Douglas Partners Responses to Sydney Metro Review Comments on Revised Numerical Modelling Report (Ref: 73019.04.R.001.Rev1, dated 27 November 2020)

Monte Scientia Project - 128 Miller Street

Victoria Cross Metro Cavern

Drawing M7 - Horizontal Displacement - Stage 6 - Building Loading

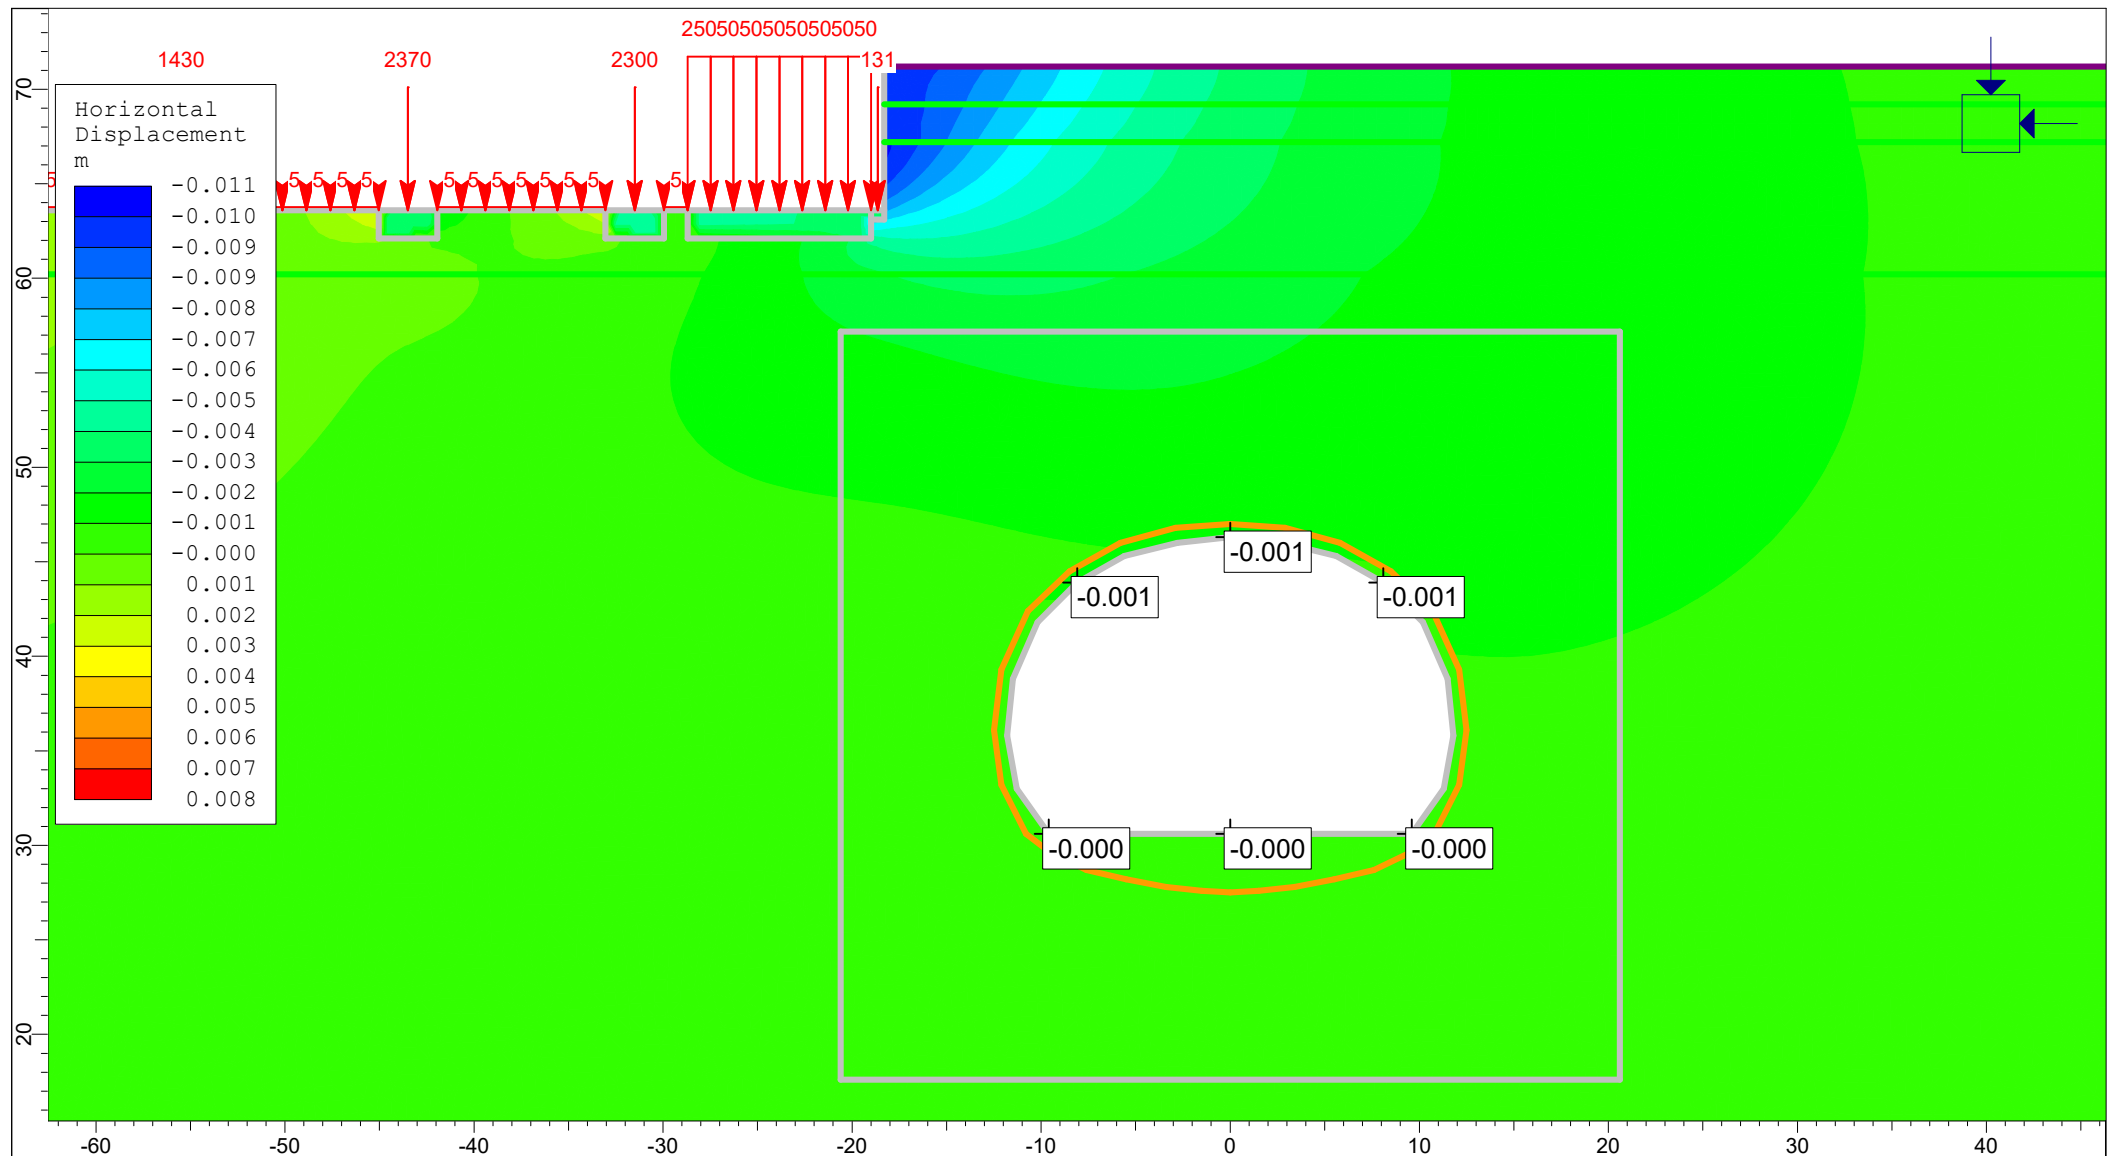
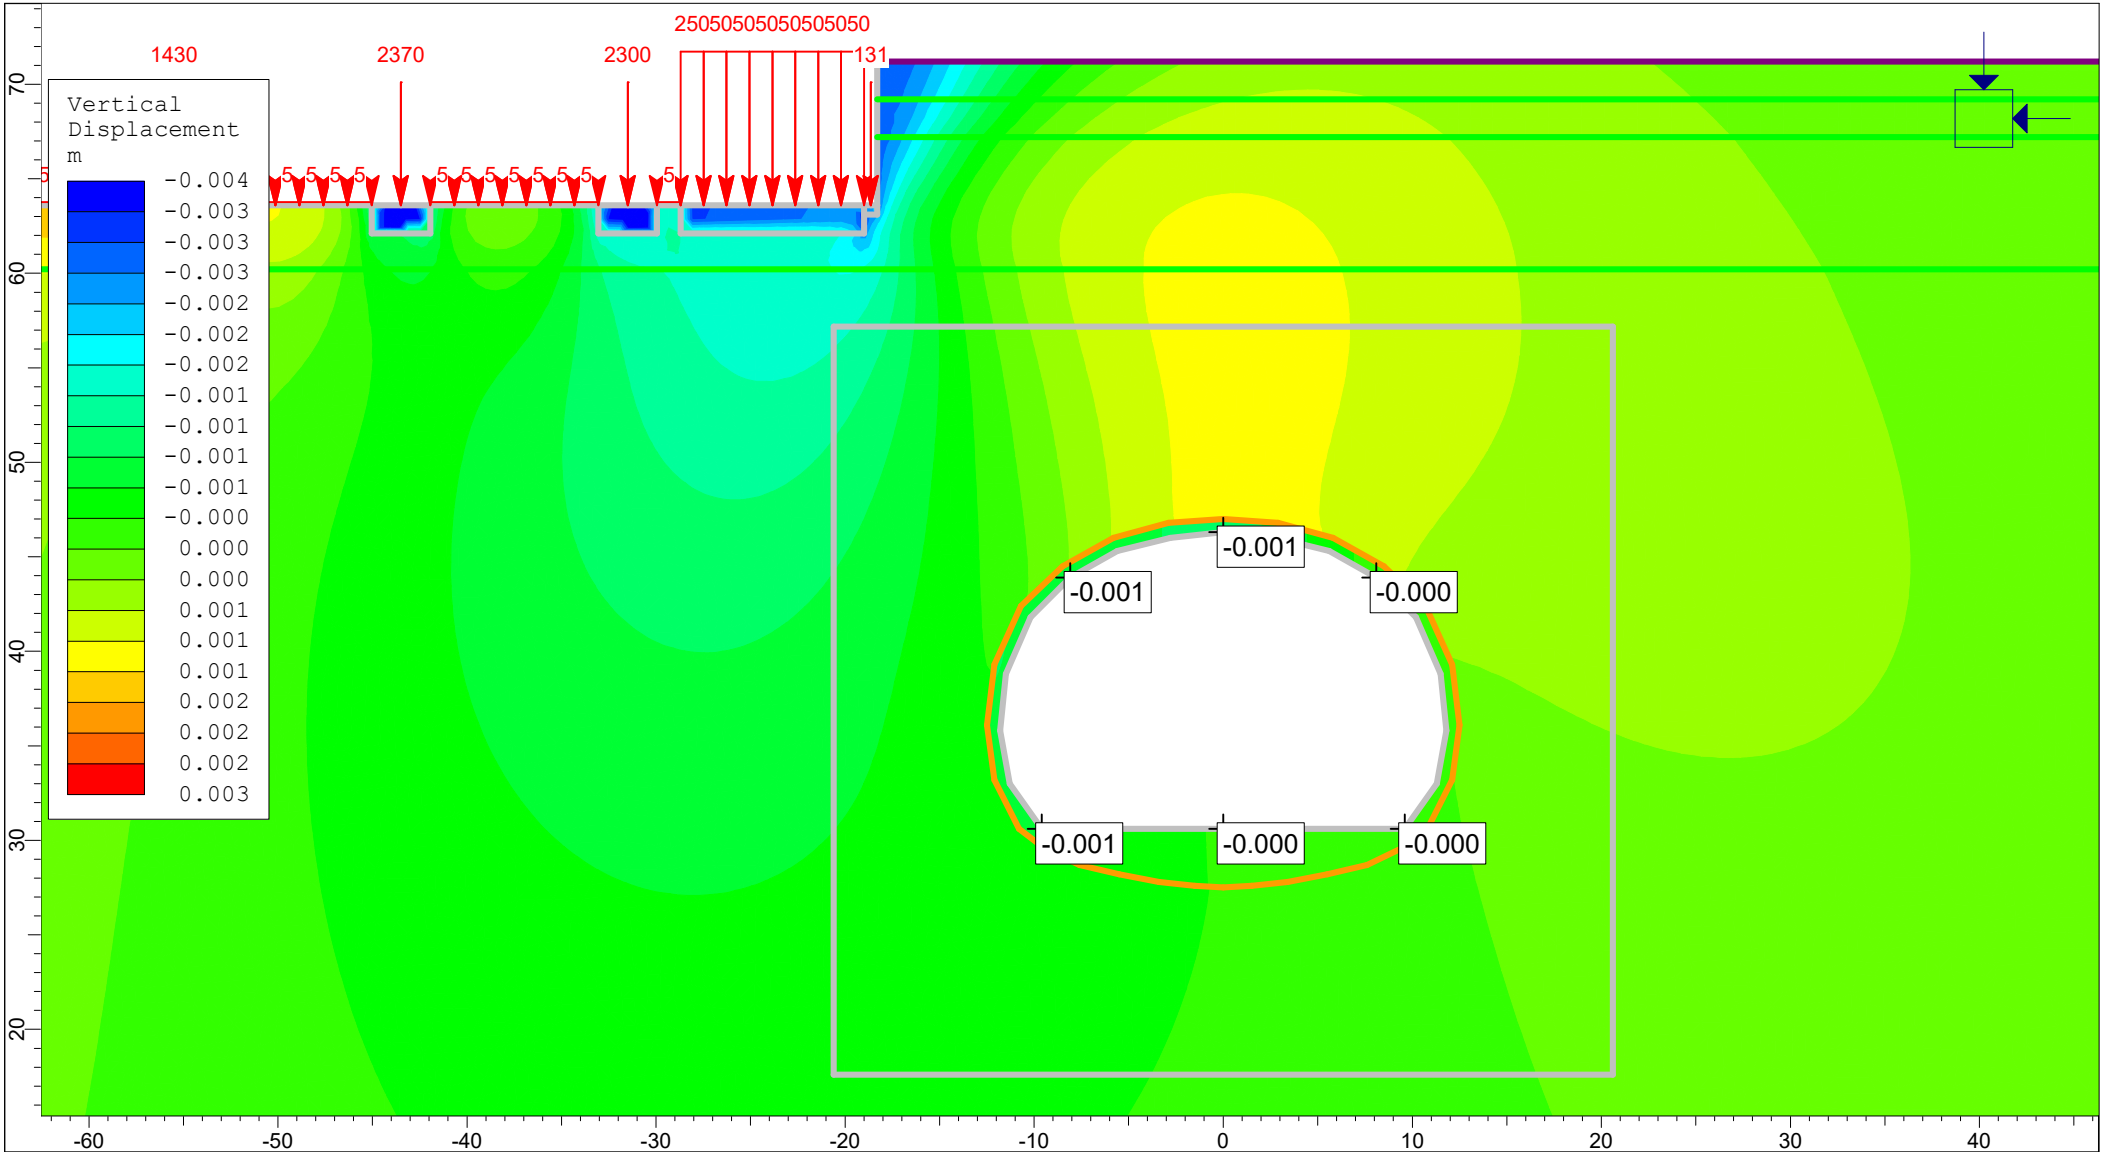
- Table 1: Building Loads Adopted in Model – Line loads adopted for footings (in kN/m) in model rather than pressures on footing base (column load by footing base in kPa).

DP - 01. 02 . 2021 The building loads has been re-modelled using bearing pressure (kPa) applied at the footing bases. The updated horizontal and vertical displacement contour output is attached, which shows negligible changes to maximum displacement values and the distributions in the vicinity of the tunnel cavern.

The updated model shows negligible changes to maximum displacement values and the distributions in the vicinity of the tunnel cavern.
